**RE: Marble Townhomes**  
**Grading Plan and Drainage Report**  
**Engineer's Stamp Date: 12/29/17**  
**Hydrology File: J18D046**

Based upon the information provided in your submittal received 01/02/2018, the Grading Plan **is not** approved for Building Permit and Grading Permit. The following comments need to be addressed for approval of the above referenced project:

EROSION AND SEDIMENT CONTROL PLAN

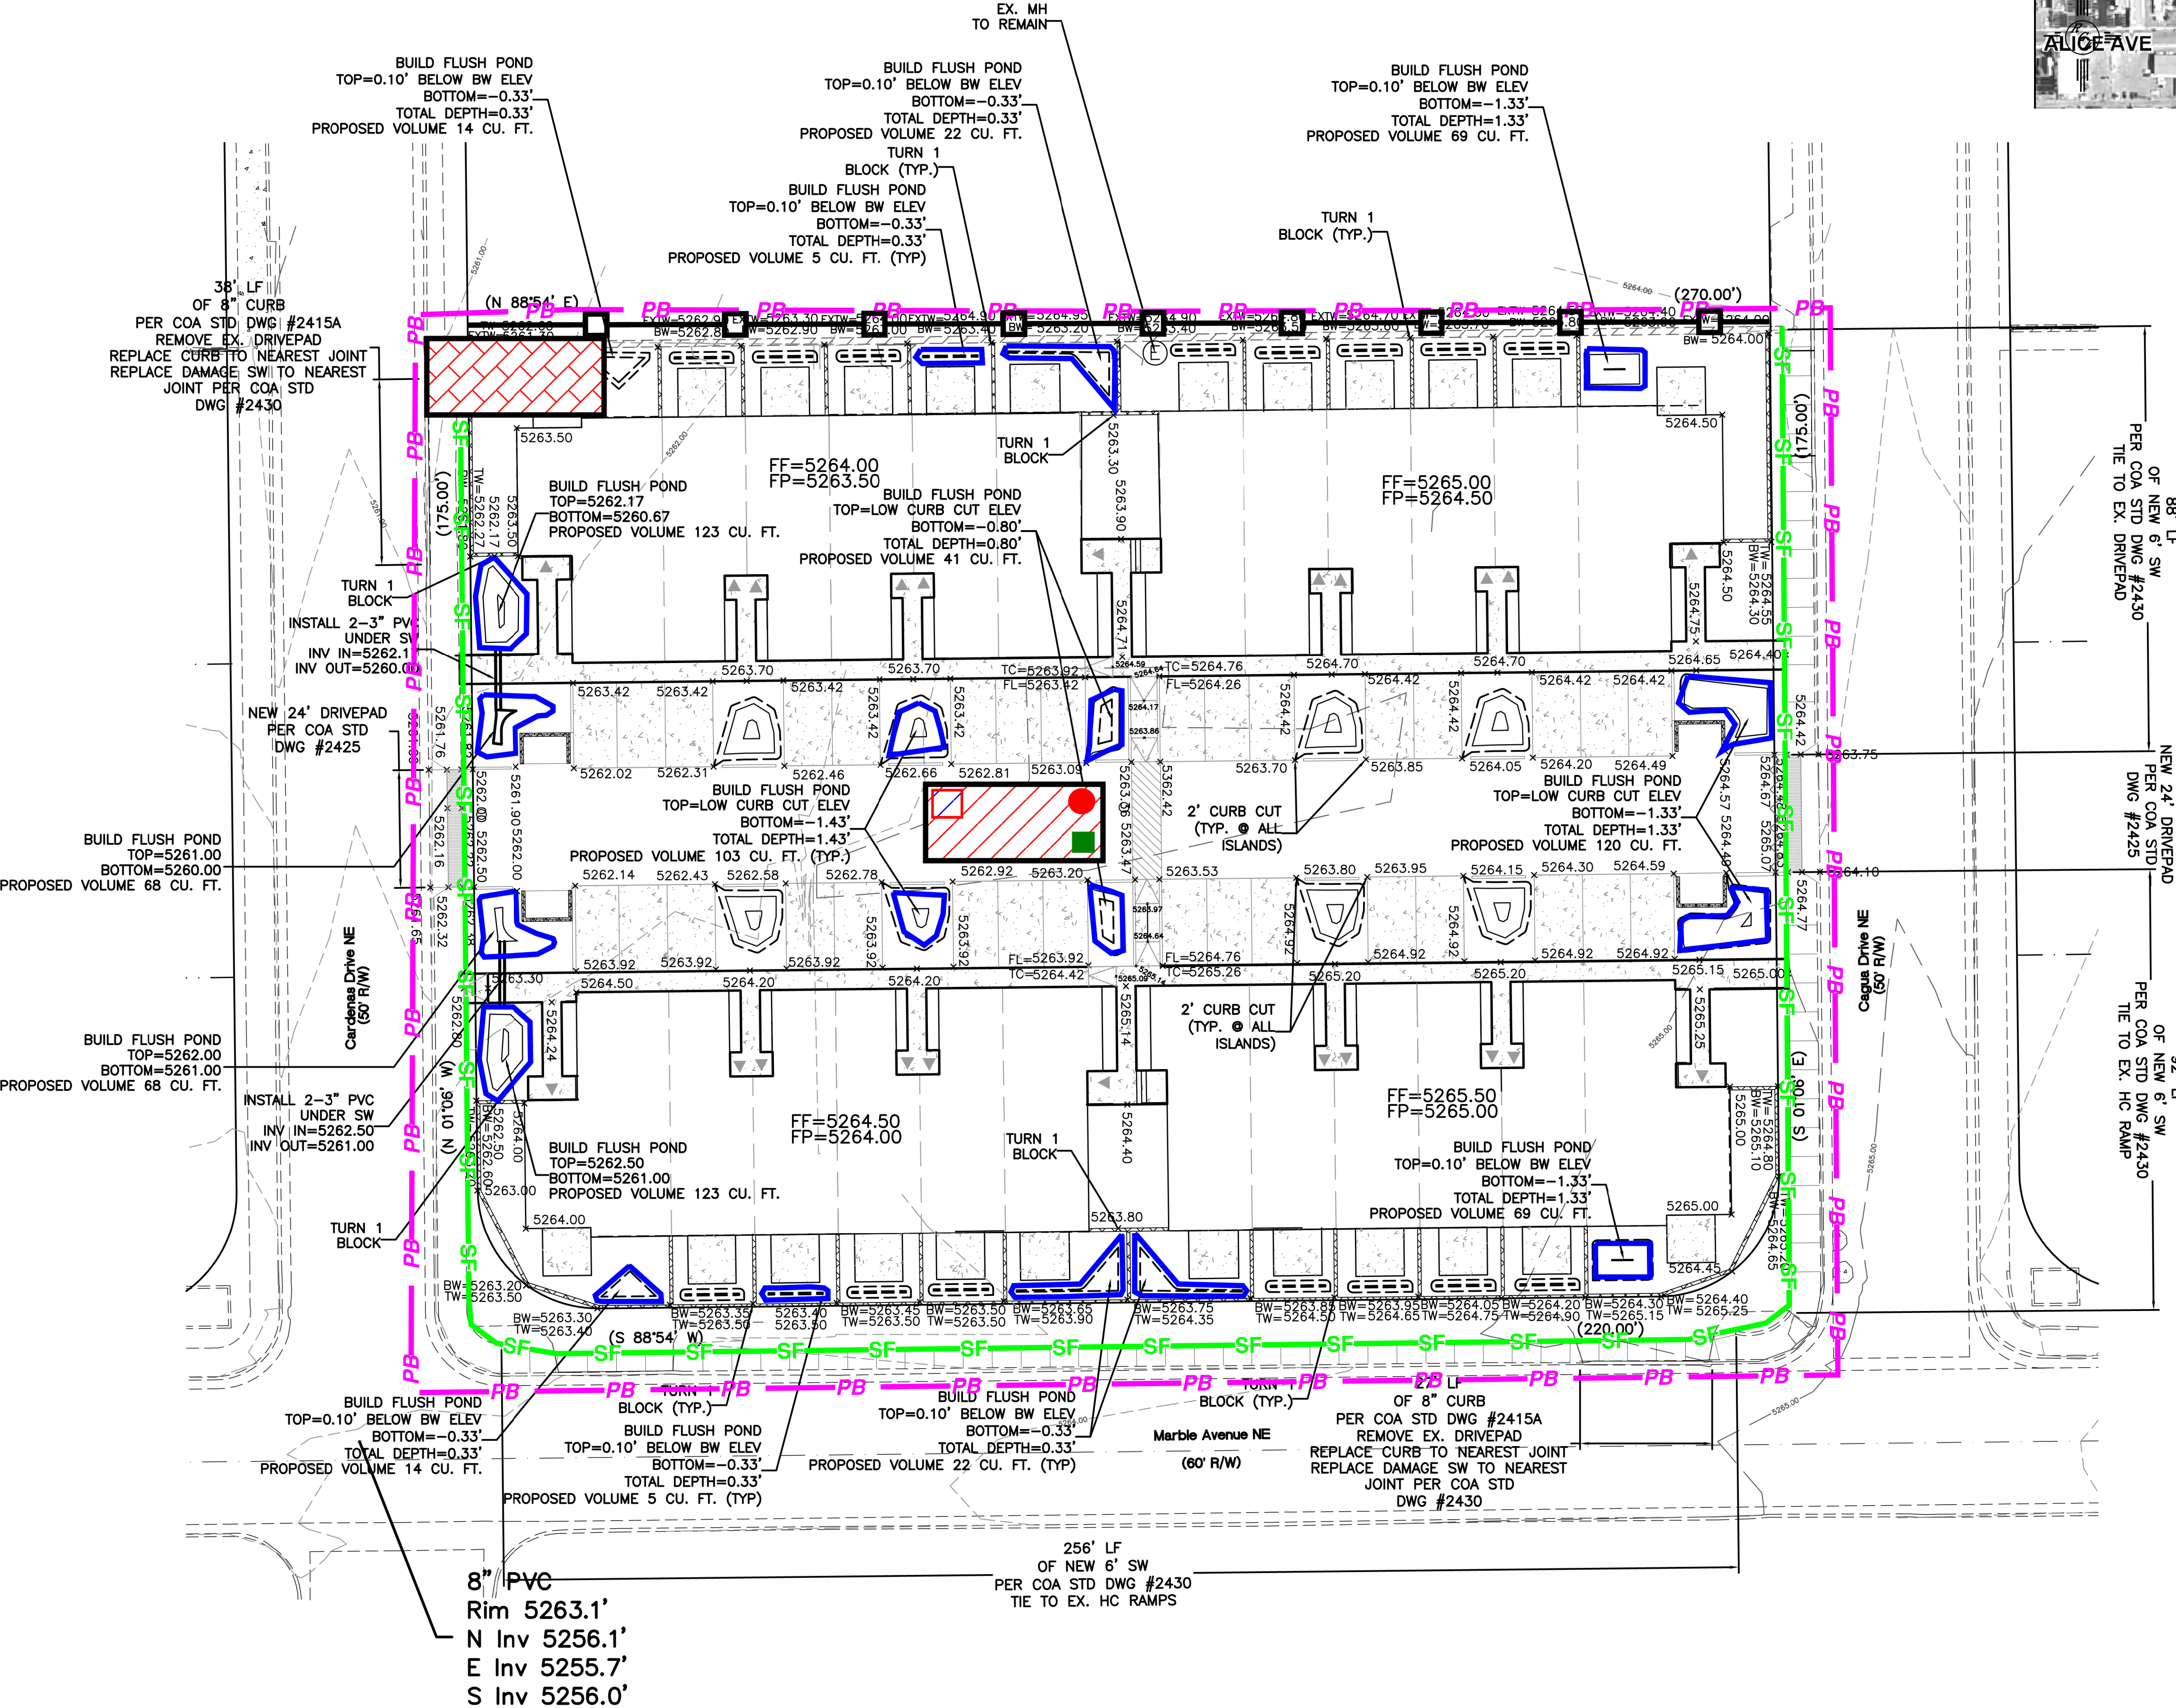
1. The site currently shows more than 1 acre of disturbance is being proposed. An Erosion and Sediment Control Plan is required and has to be submitted to the storm water quality engineer (Curtis Cherne, PE, [ccherne@cabq.gov](mailto:ccherne@cabq.gov)). Hydrology's approval for Grading or Building Permit will not be given until the submittal of the ESC Plans.
2. Please provide a note showing the first flush required volume and the first flush provided volume.
3. Please provide a typical detail for the turned CMU block. This block needs to be at least four (4) inches above the proposed grade to avoid clogging.
4. There are two missing remove drivepad & replace with curb & gutter note as outlined in the following photo.
